**Comments State Significant Development Application - 200 Aldington Road Industrial Estate (SSD-10479)**

## **Attachment 1 – Detailed comments on SSD-100479**

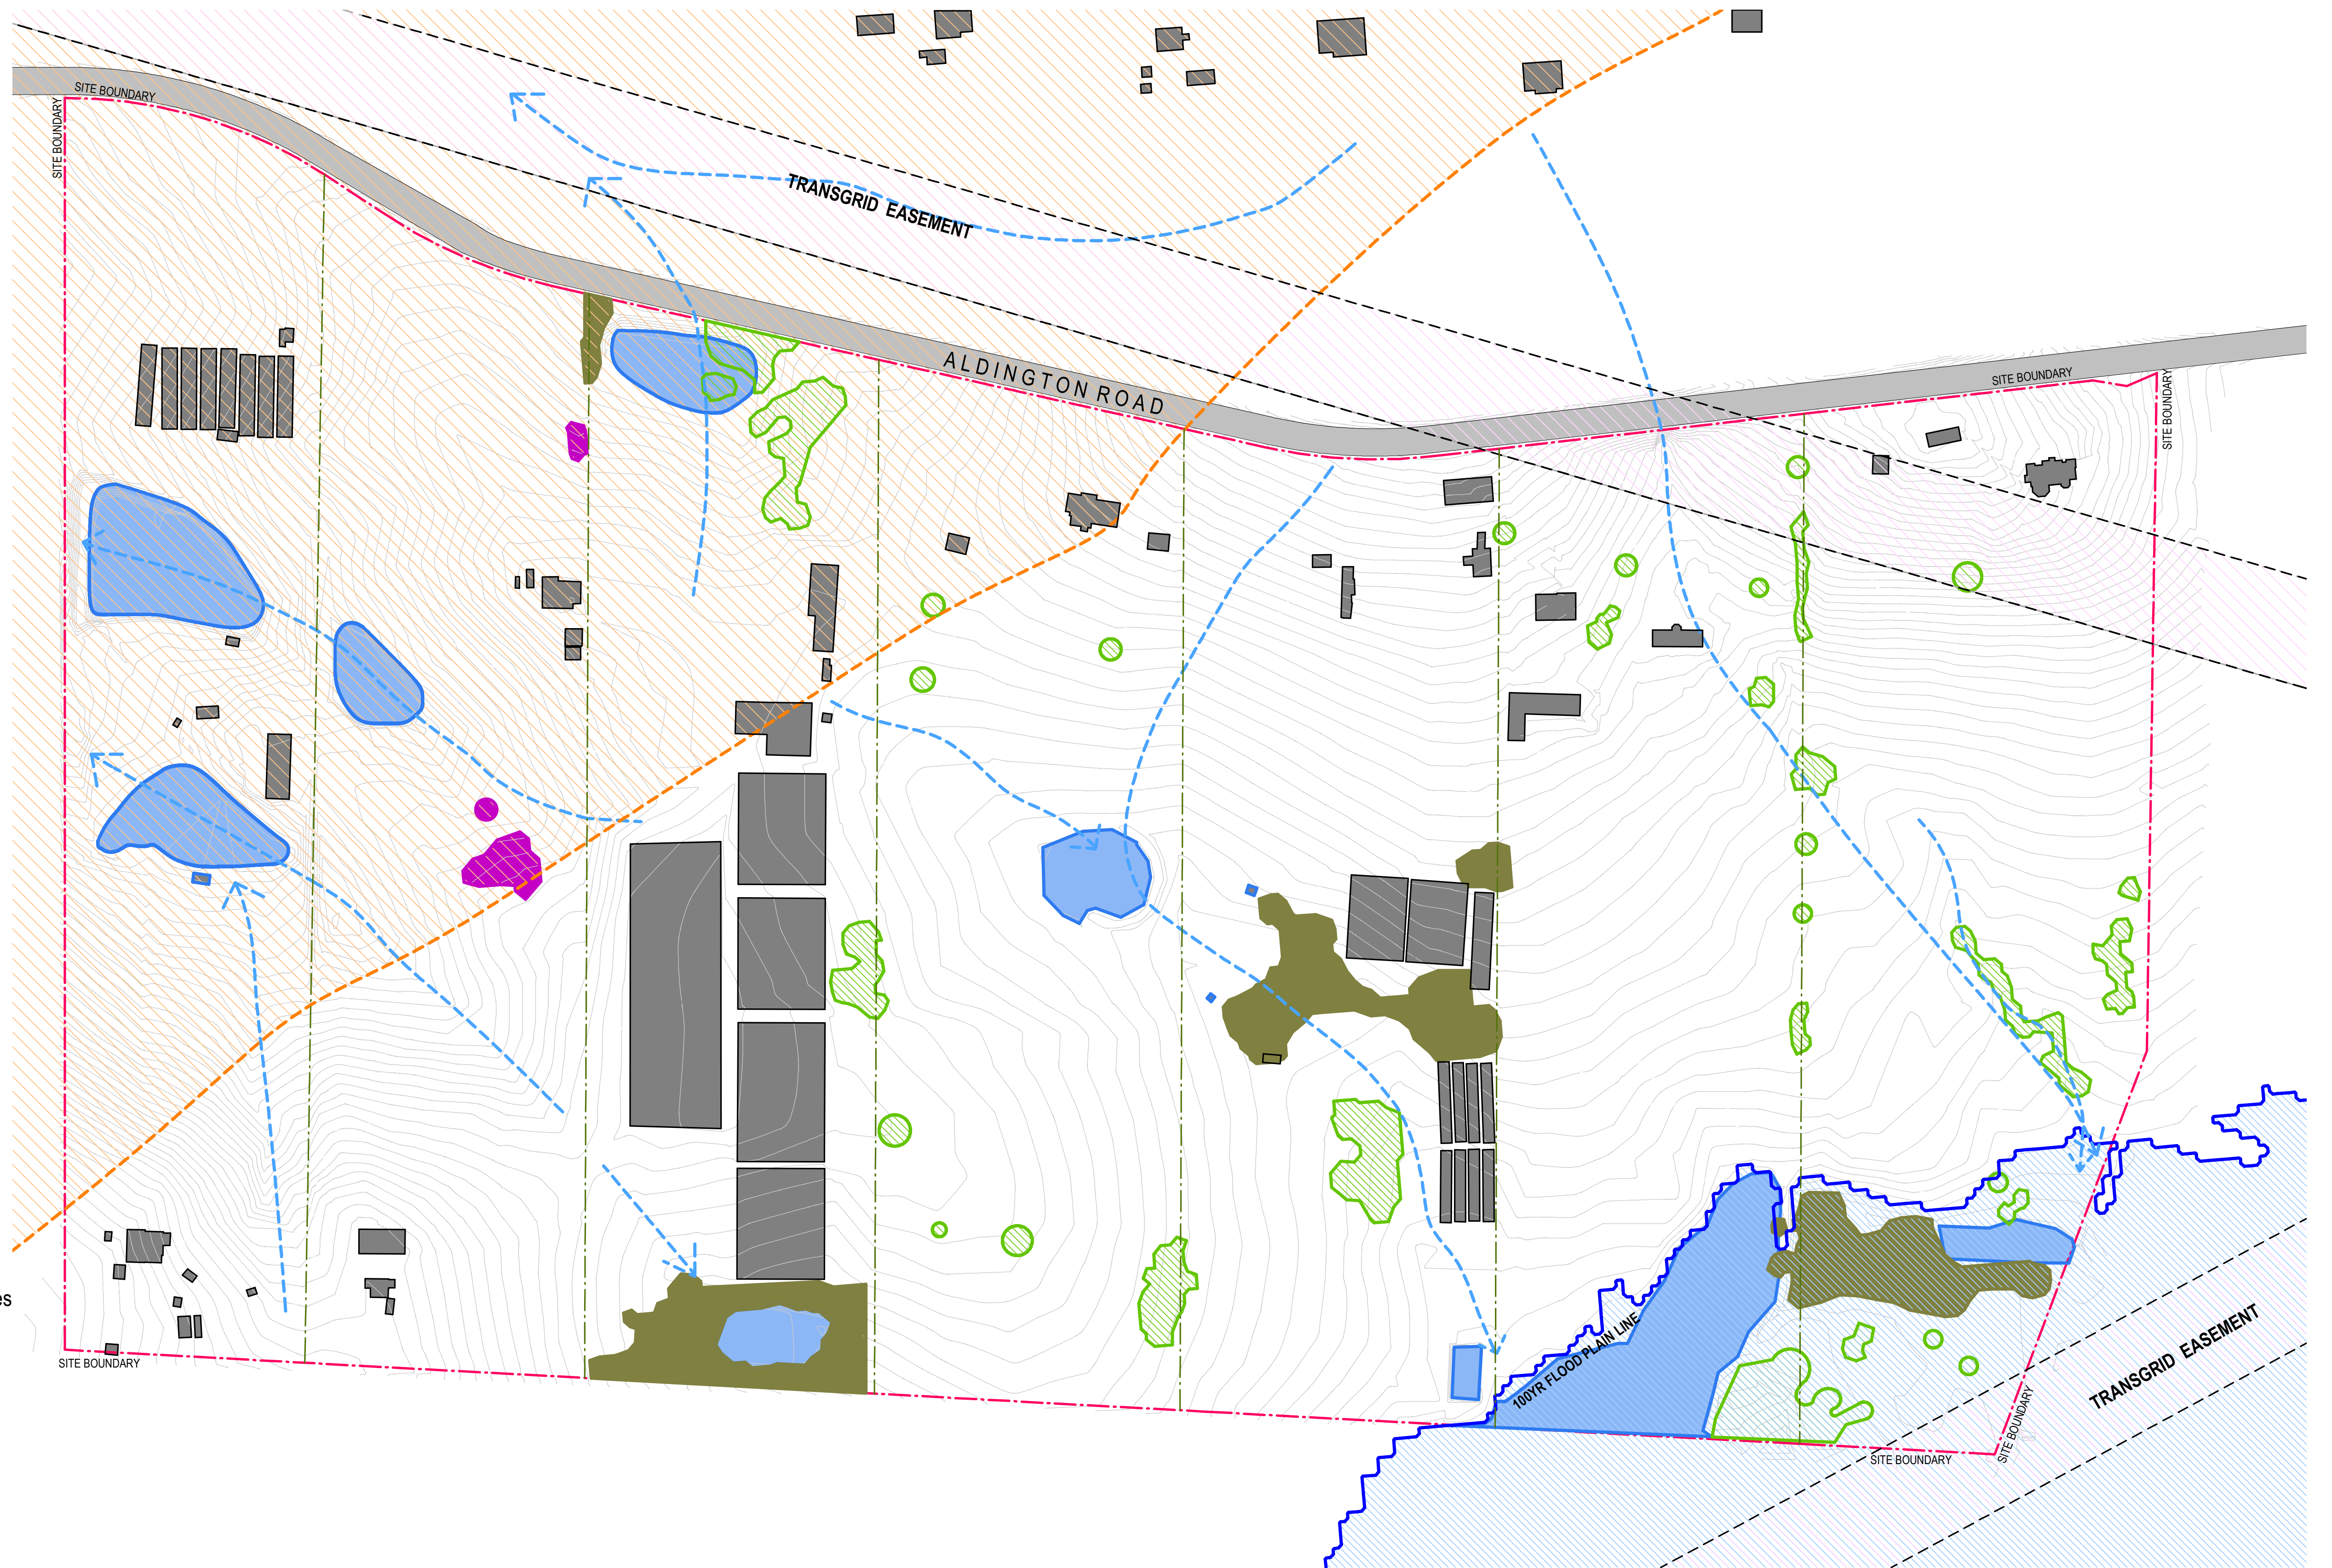
Generally, the proposed development appears to be consistent with these. However, the Planning Partnership is concerned about the placement of the building footprints and parking areas partly within the 1:100 flood area under the concept plan, particularly lots C and G (see Figure 1) and the impact such development will have on flood waters. In addition, the Planning Partnership is also concerned about the building footprint of Lot G and associated parking which is partly within land zoned RE2 Private Recreation (see Figure 2). It is recommended that the building footprints be wholly contained within the IN1 General

Industrial zone and above the 1:100-year flood prone land. If approved as per the current application, it could set a precedent across the Aerotropolis which is not desirable and would be inconsistent with the strategic planning objectives of the WSAP.
